STAFF REPORT

TAMARACK RIDGE PEFORMANCE BASED CLUSTER PRELIMINARY PLAT

TO: Kittitas County Hearing Examiner
FROM: Kittitas County Community Development Services Staff
RE: Tamarack Ridge Preliminary Plat (LP-07-00018)
DATE: January 10, 2013

COVER SHEET  
OF  
**TAMARACK RIDGE**  
A PORTION OF SECTION 01, TOWNSHIP 19 N., RANGE 14 E., W.M.  
KITITITAS COUNTY, WASHINGTON

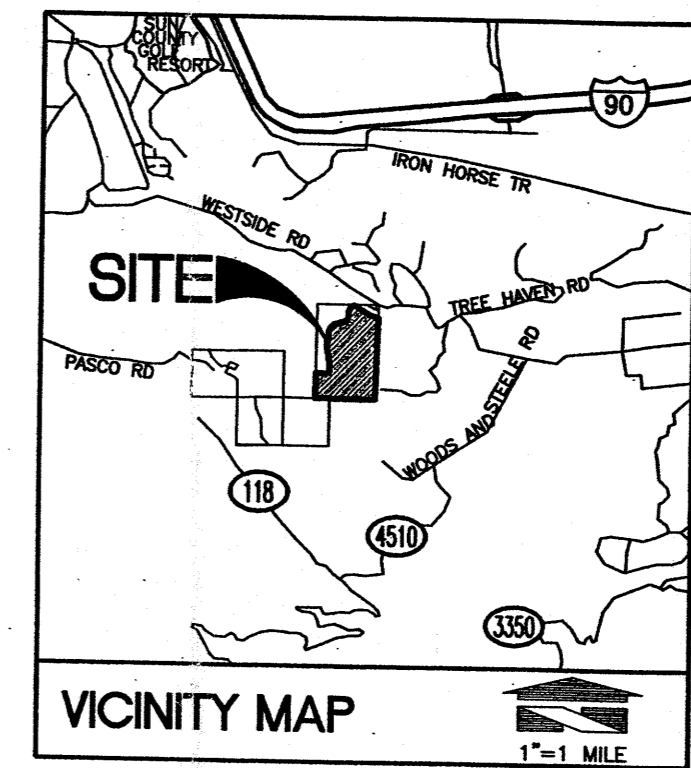
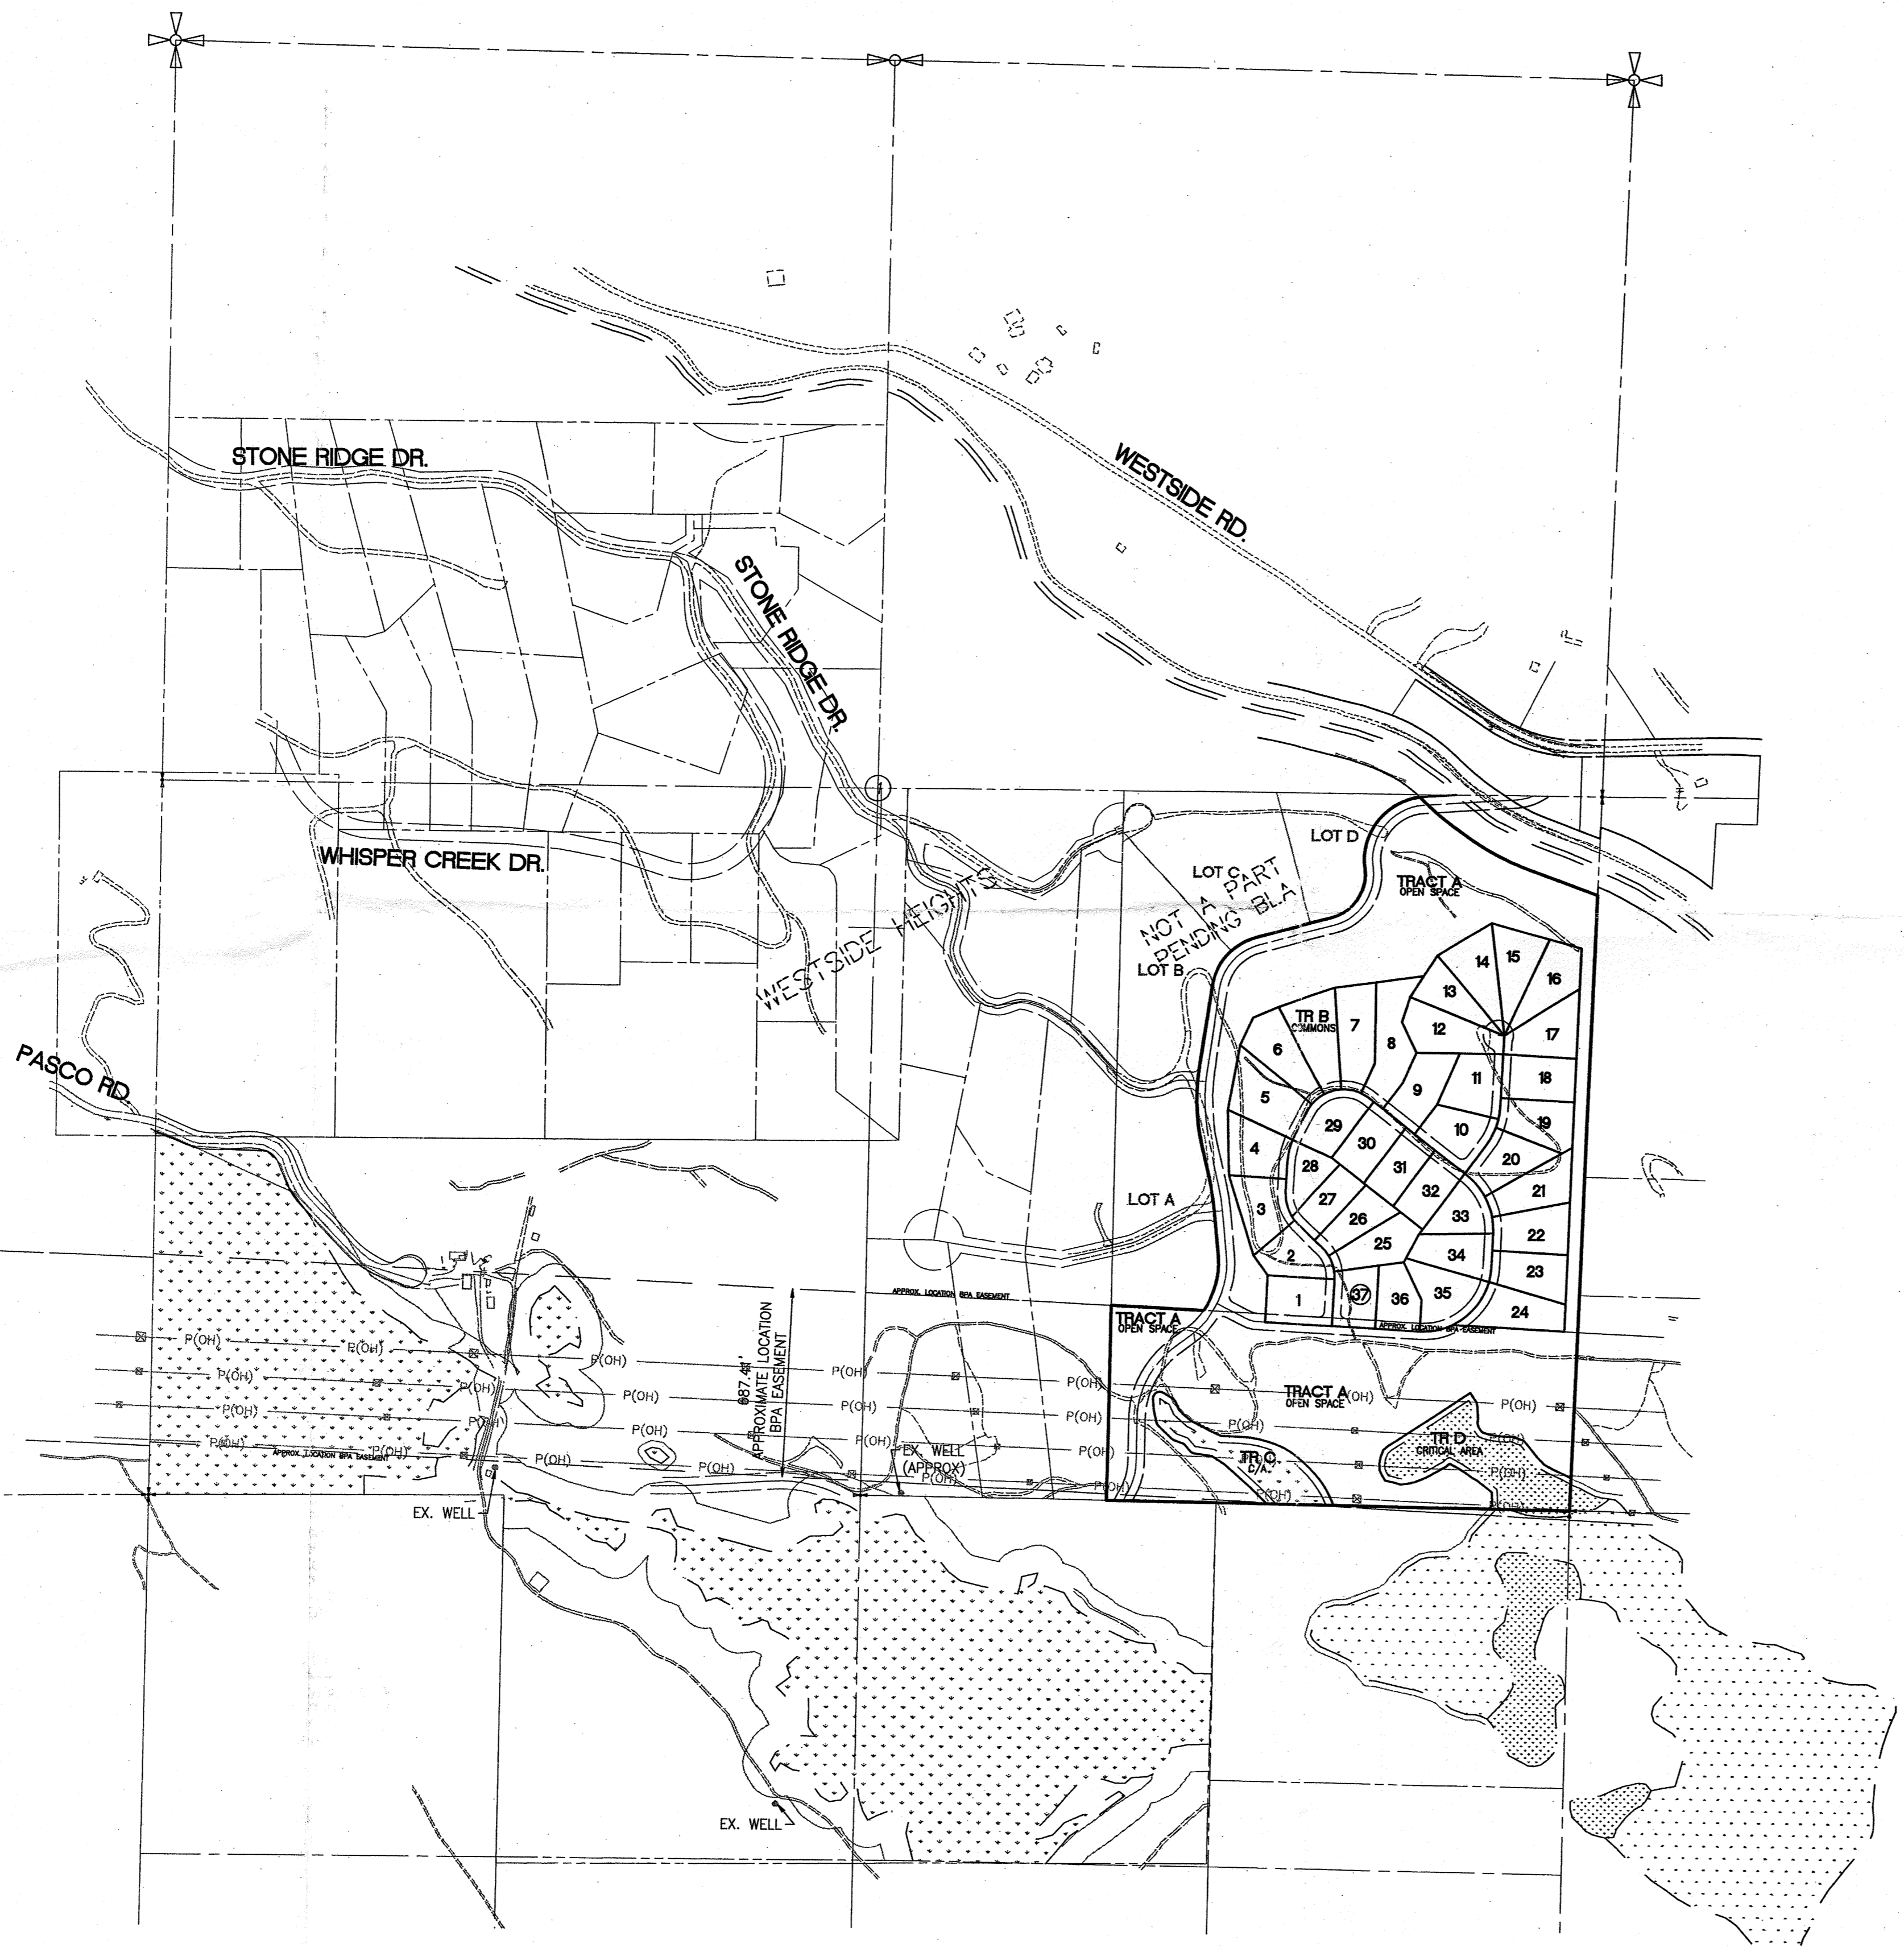
This proposal is not consistent with the Kittitas County Subdivision Code for Preliminary Plats. The page size is too large. KCC 16.12 requires page sizes to be 18 x 24 inches, and the submitted pages are 24 x 36 inches.

- b. The final plat shall be drawn to such a scale as to make a sheet eighteen inches by twenty-four inches. Should this size sheet unduly congest the drawing, the plat may be submitted on two or more sheets of the above dimensions. The perimeter of the subdivision shall be depicted with heavier lines than appear elsewhere on the plat. A marginal line shall be drawn completely around each sheet, leaving an entirely blank margin of one inch on the sides. The scale shall be one (1) inch equals two hundred (200) feet, or greater, unless otherwise approved by the director.

Title
SITE PLAN
OF
TAMARACK RIDGE

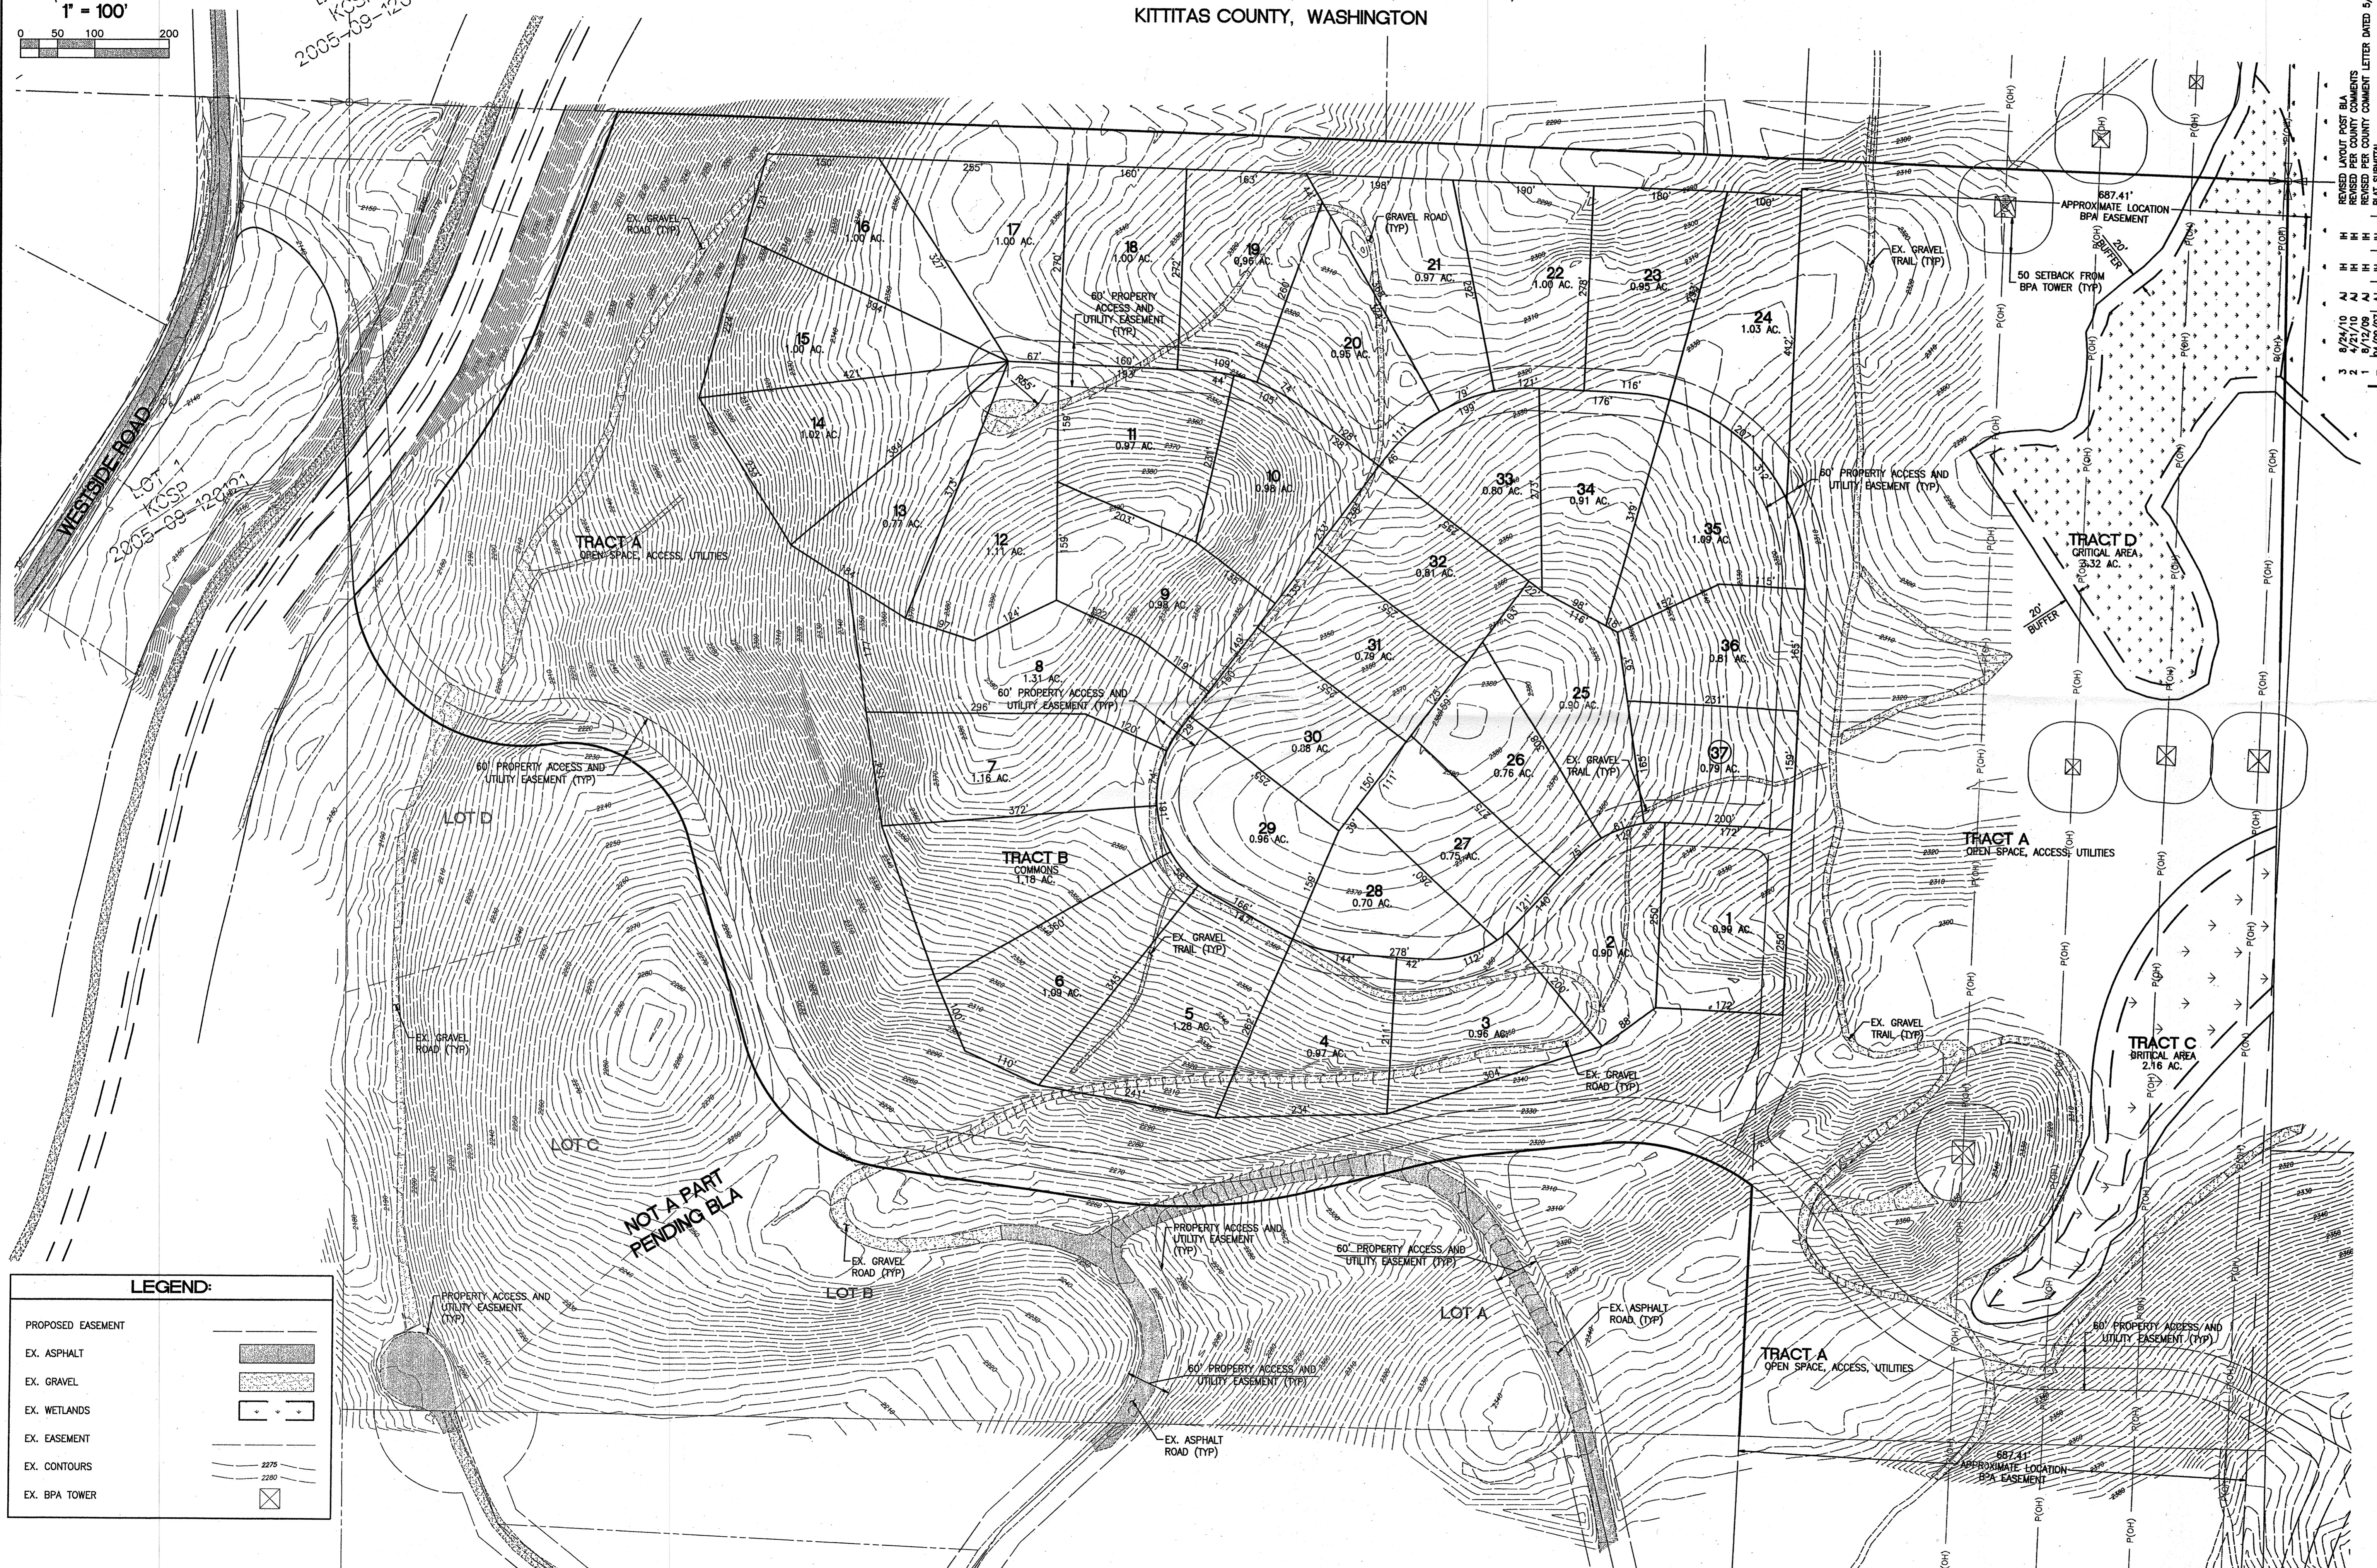
- ss. No slope or grade greater than 12% shall be allowed.
- tt. Secondary access, as shown on the plat maps, shall meet minimum Kittitas County Road Standards, as well as the International Fire Code requirements.

- d) The second access to the proposed plat is planned to be located within the Bonneville Power Administration (BPA) easement. Based on BPA policies, adjustments to the road locations may be required. If the road locations are moved, Public Works shall review the new road locations for conformance to Kittitas County Road Standards existing at time of final plat approval to ensure a 25 mph design speed. All required approvals for the construction of the second access shall be obtained from the BPA and shall comply with all applicable conditions and restrictions contained within the easements of Bonneville Power Administration (BPA). Kittitas County Department of Public Works shall review such approval, and review the road for conformance with County Road Standards prior to final plat approval.
